**WEST SUSSEX COUNTY COUNCIL
STRATEGIC PLANNING CONSULTATION**

DATE: 16/09/2014

SUBJECT: M/61/14/PL - Conversion of existing residence into 3 No new flats (resubmission following M/13/14/)

The Litten, Ancton Lodge Lane, Middleton-On-Sea, Bognor Regis, PO22 6LZ

Ground Floor / Site Plan 1:100

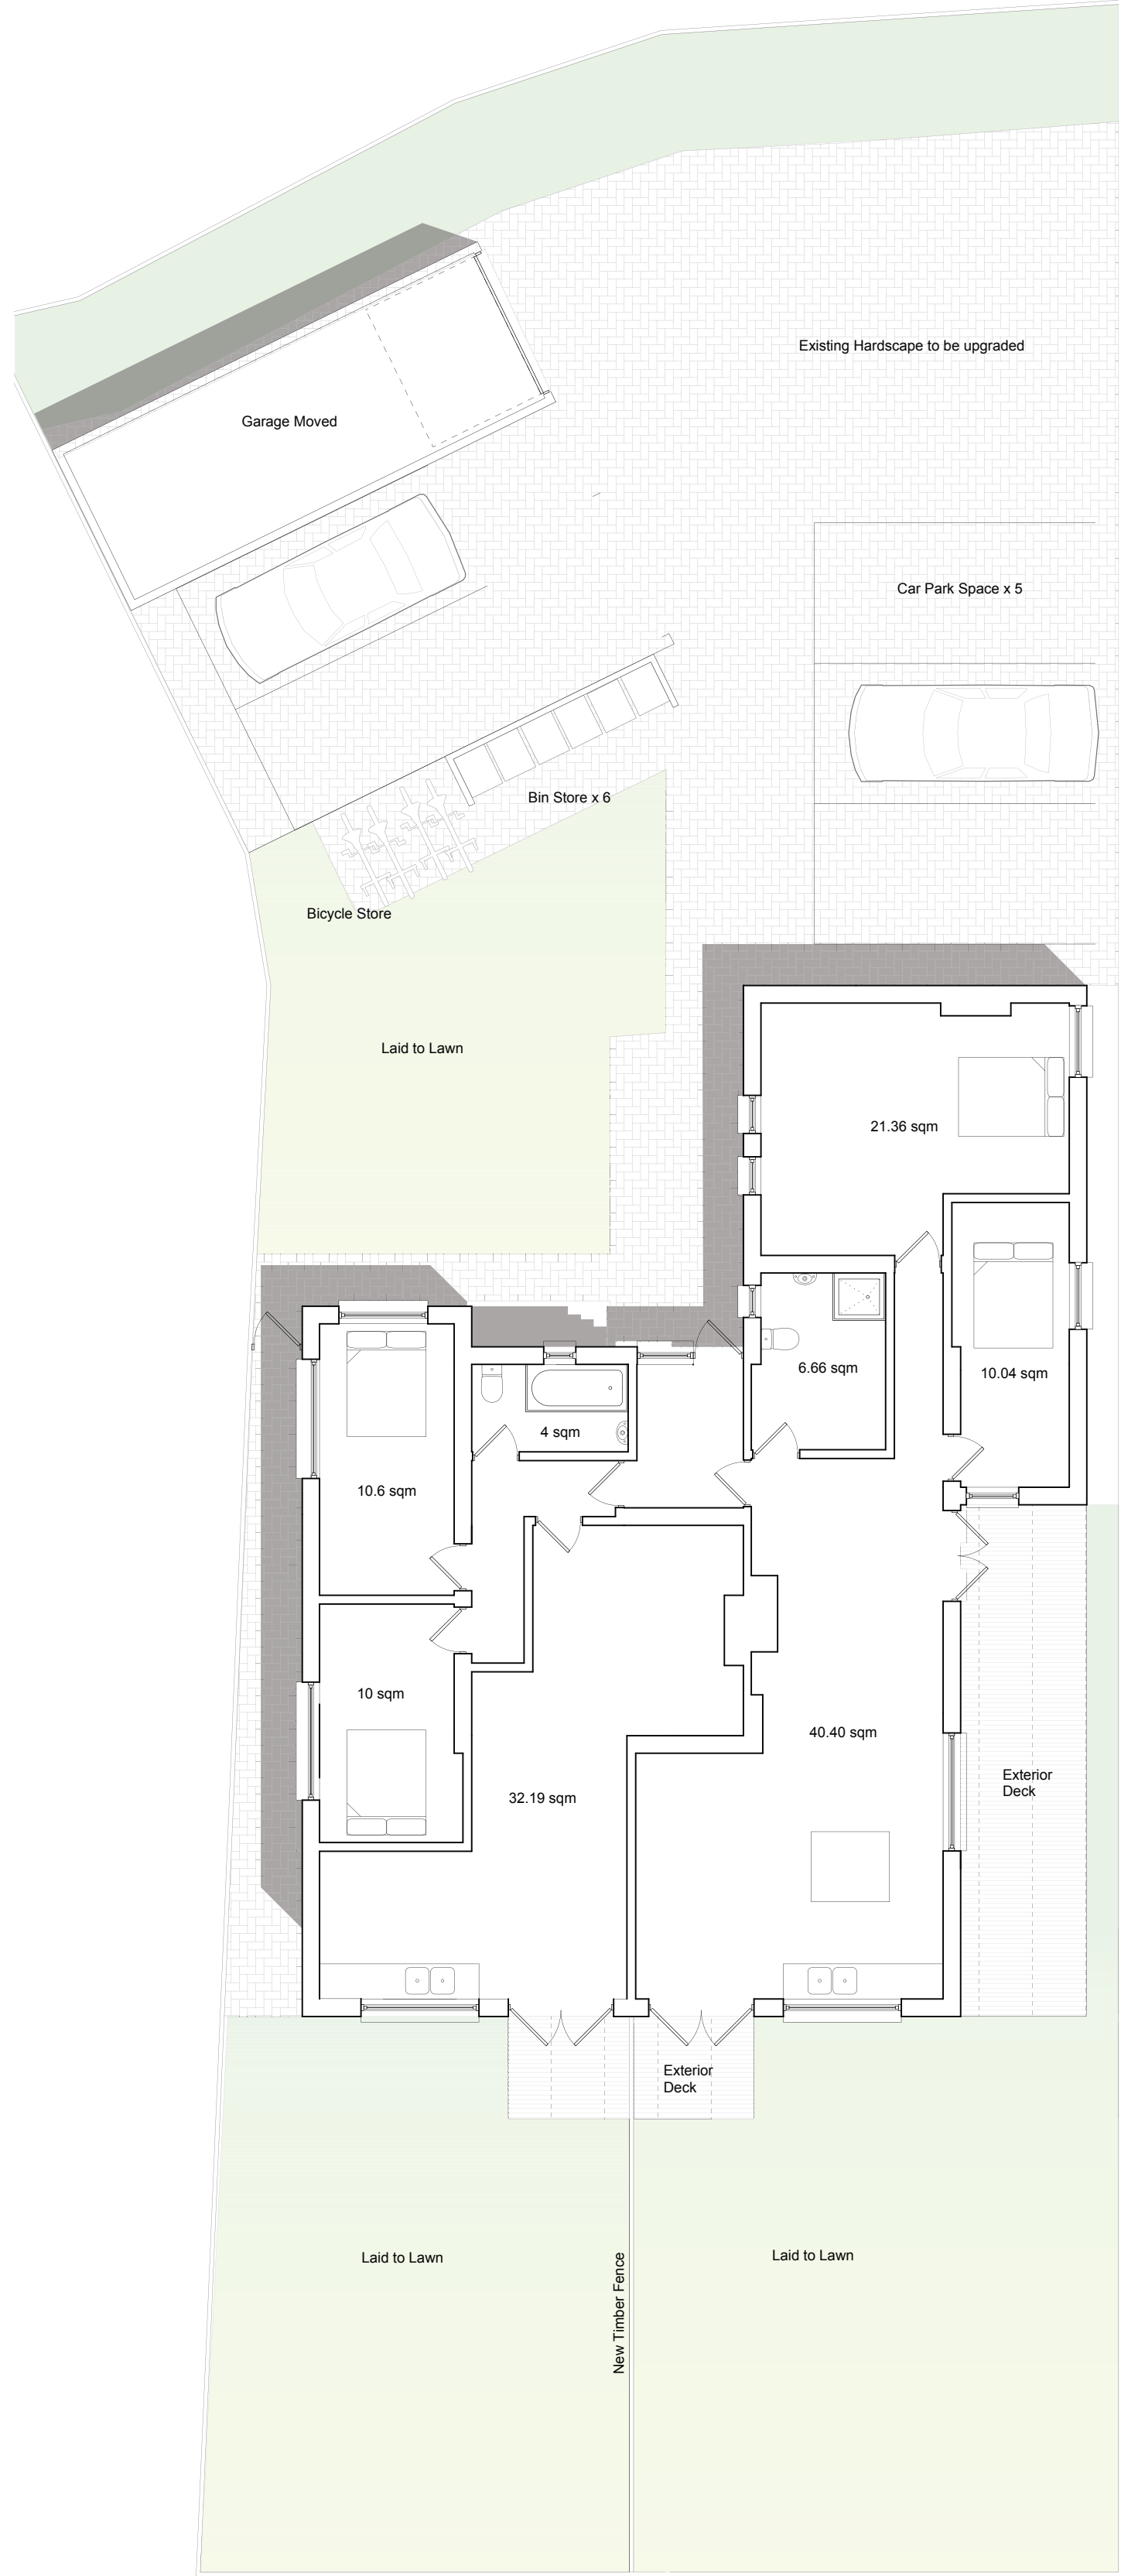
From inspection of the plans and information available a provision of 5 unallocated parking spaces will be available for the residents. Having checked WSCC's car parking demand calculator for a development of this size in this area, it would appear to meet the recommended number of spaces.

A provision of cycle parking is proposed. It is advised that this is secure and covered and in line with WSCC's standards (1 cycle space for per flat). This will help promote sustainable transport and further mitigate the need for a private car.

The access to the site is narrow, however there are passing places situated along the lane. The ability to turn on site using the private lane is achievable, allowing a vehicle to exit on to the highway in the forward gear. The access on to the highway, in visibility terms, is acceptable to support this development.
